## PLANNING CONSULTATION RESPONSE

<b>Application No</b>	2026/0054
<b>Proposal</b>	Installation of a modular banking cabin.
<b>Address</b>	Tesco Stores, Market Lane, Penistone, Sheffield, S36 6TS
<b>Date of Consultation Reply</b>	18.02.2026
<b>Consultee</b>	Charlie Atkinson Design & Conservation Apprentice

# 01 FRONT ELEVATION

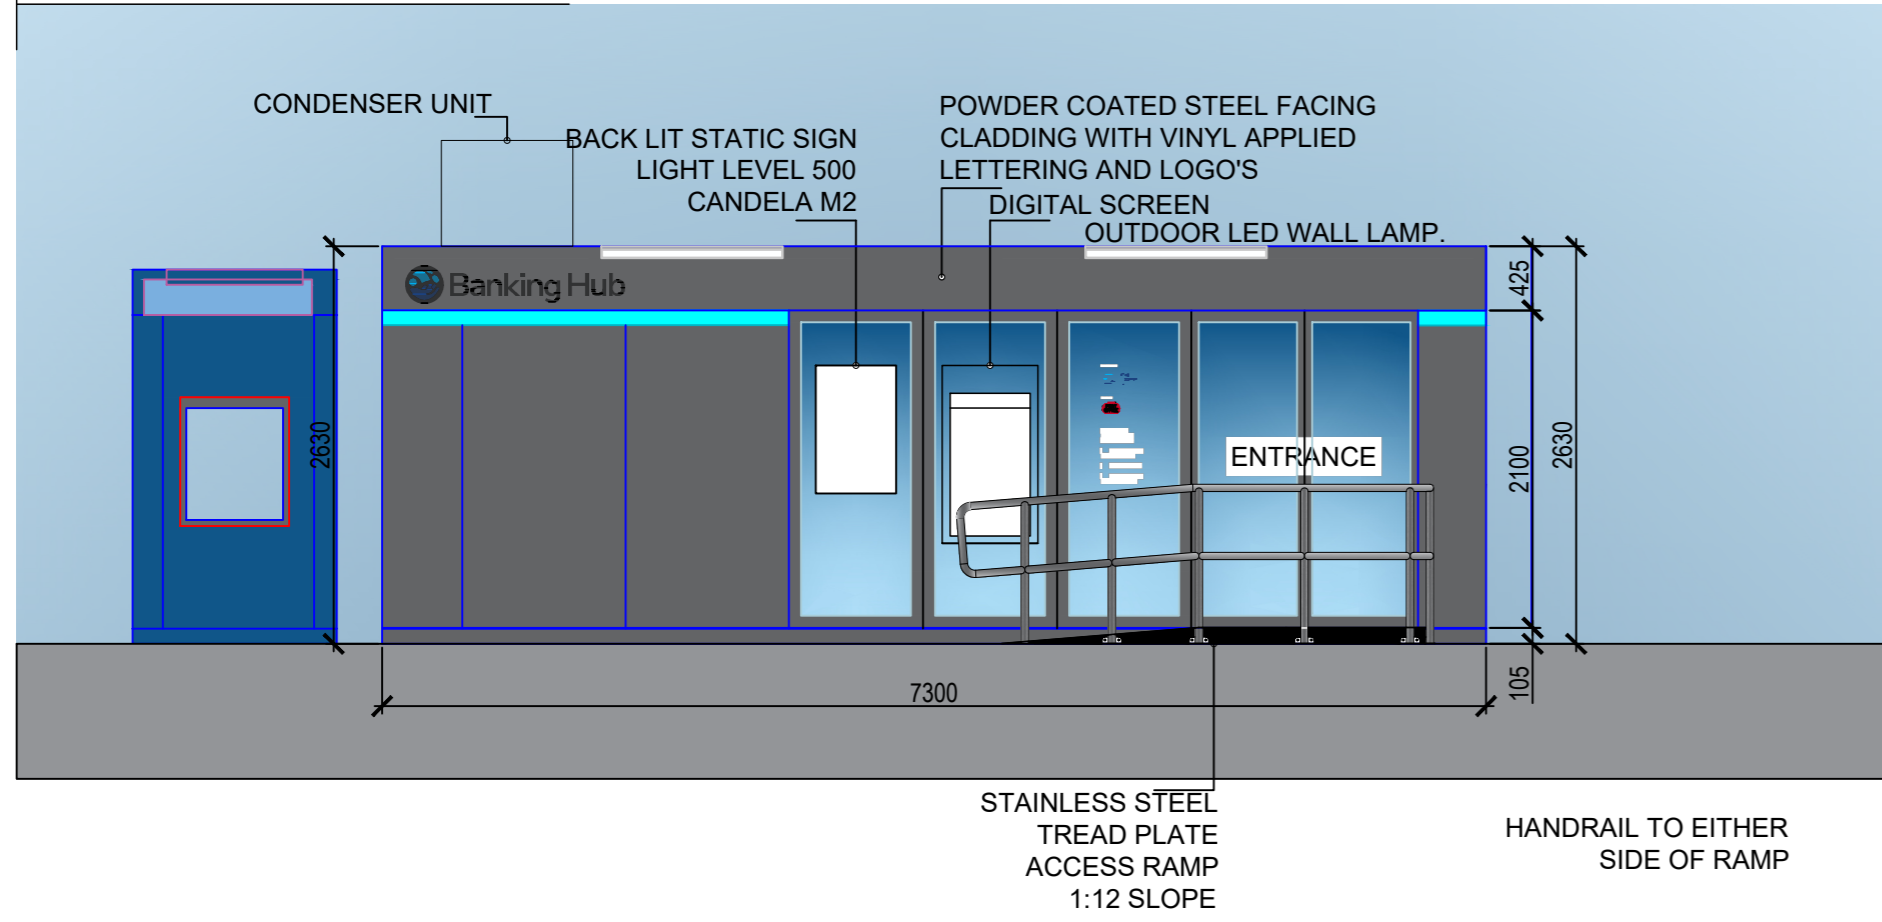
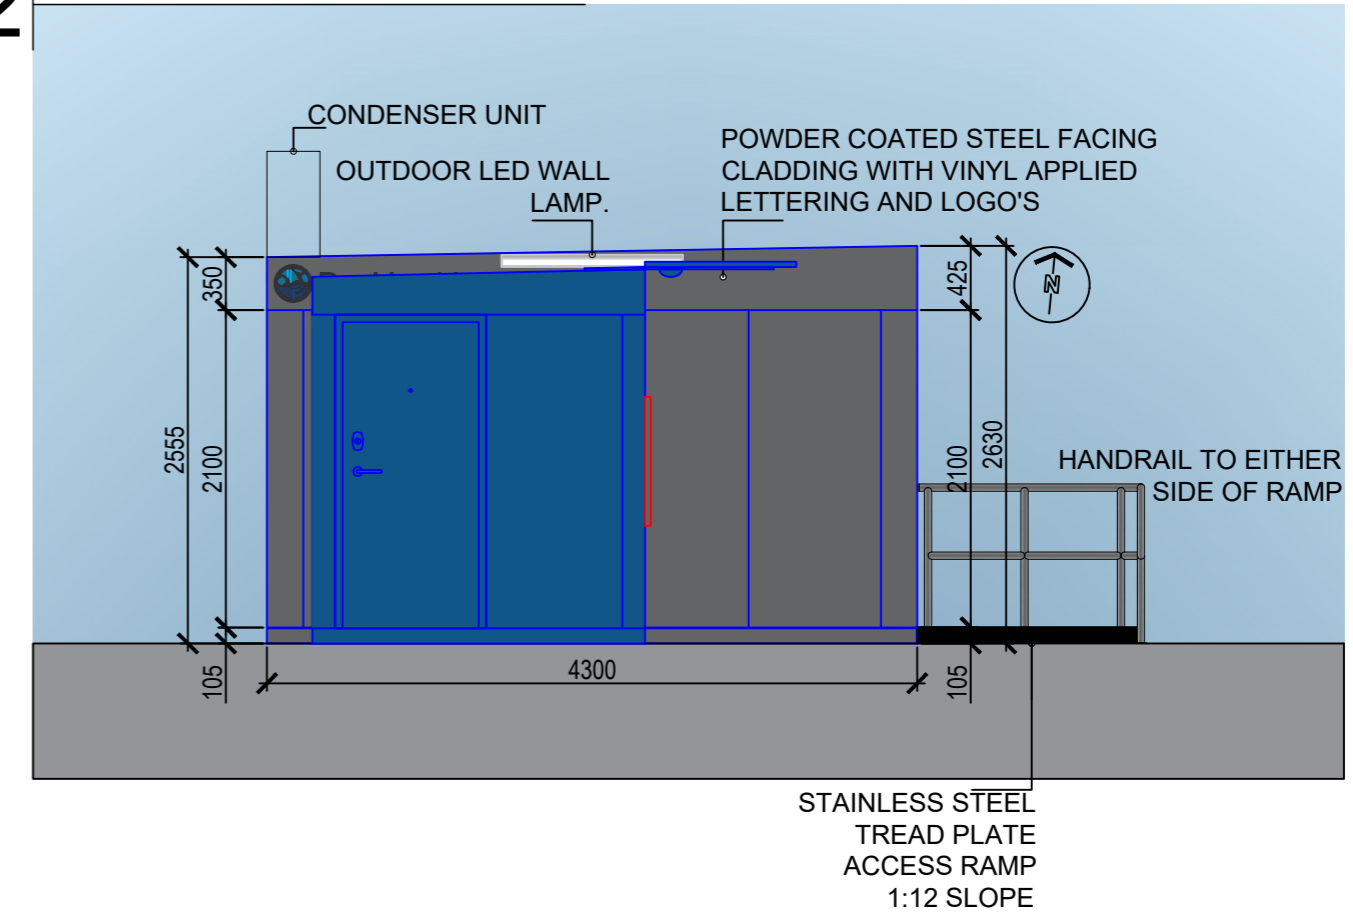
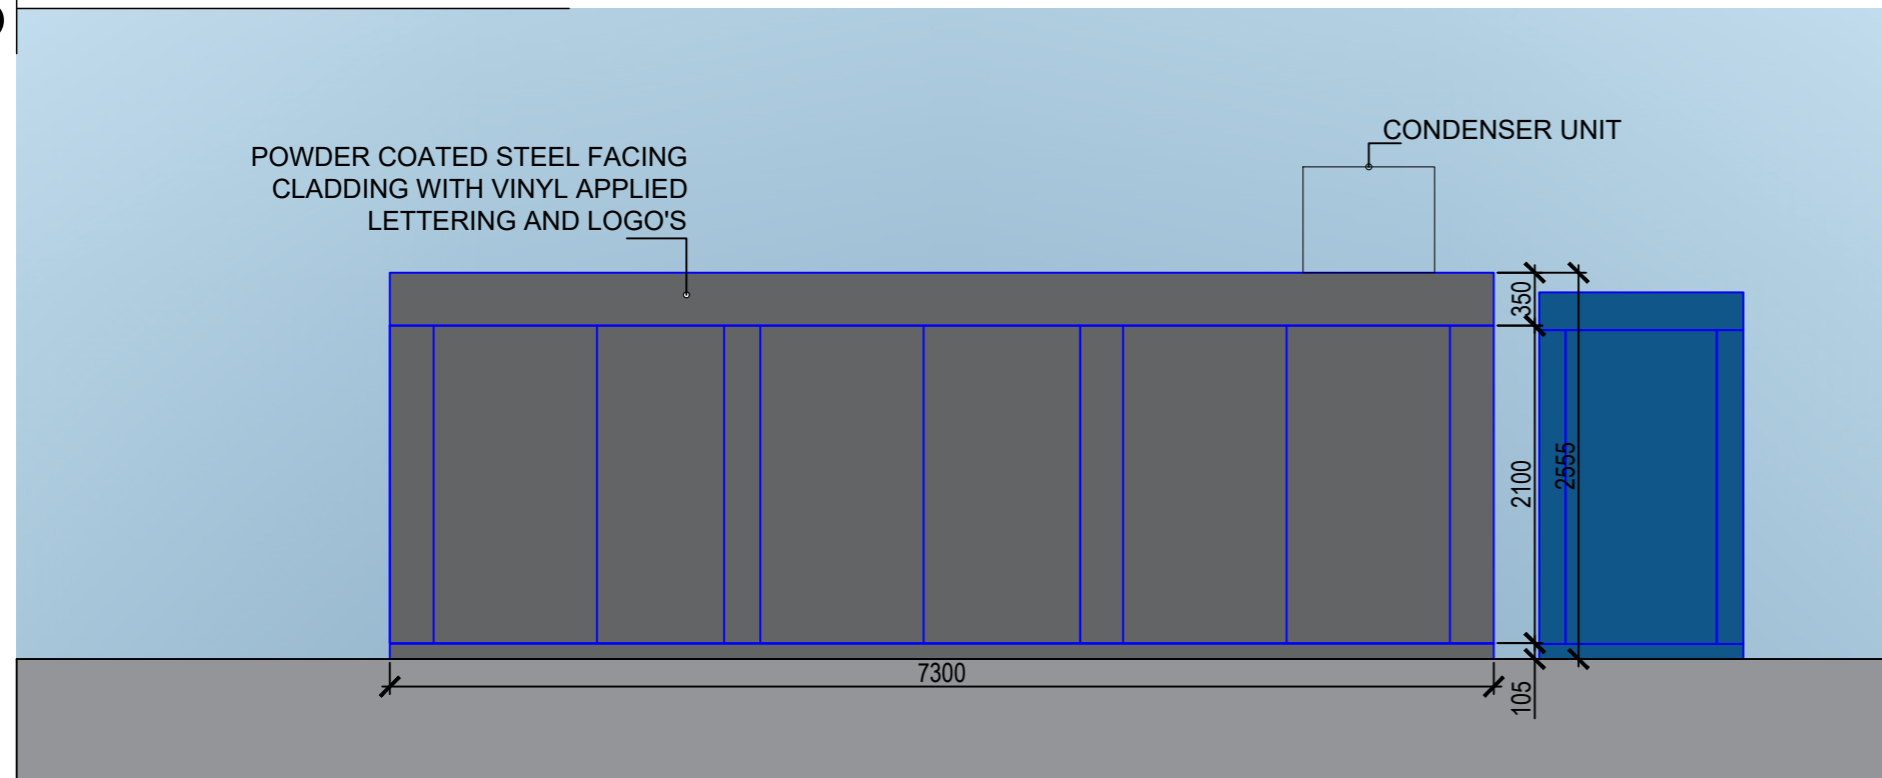
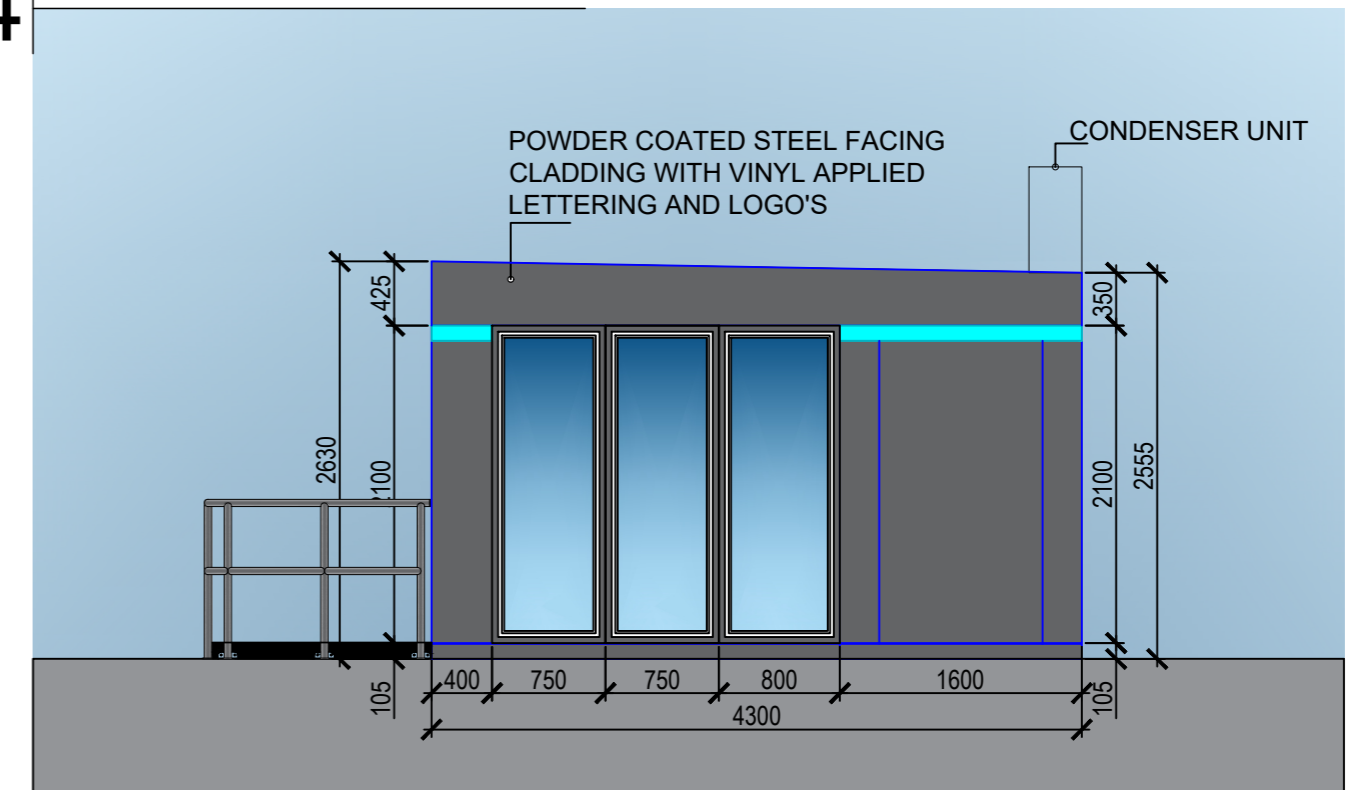
The proposed banking unit would provide a clear benefit to the Penistone area by introducing a local banking hub within the market town. From a conservation perspective, its location raises no concerns in terms of impact on the conservation area or its significance. However, clarification is required in relation to the colour and external finish of the unit. The submitted elevations indicate a powder-coated steel structure, which is considered acceptable in principle, but no final colour or finish has been specified.

While there are no concerns in principle, it would be helpful to explore whether alternative colour options - such as a lighter grey - could be used to better respect the character of the conservation area and the recent Tesco development, and to avoid a dark or visually prominent appearance.

Consequently, the modular banking unit in principle is considered to offer a positive contribution to Penistone. However, the colour and finish of the unit should be clarified to ensure its appropriateness in this location in respect to the conservation area and recent development.
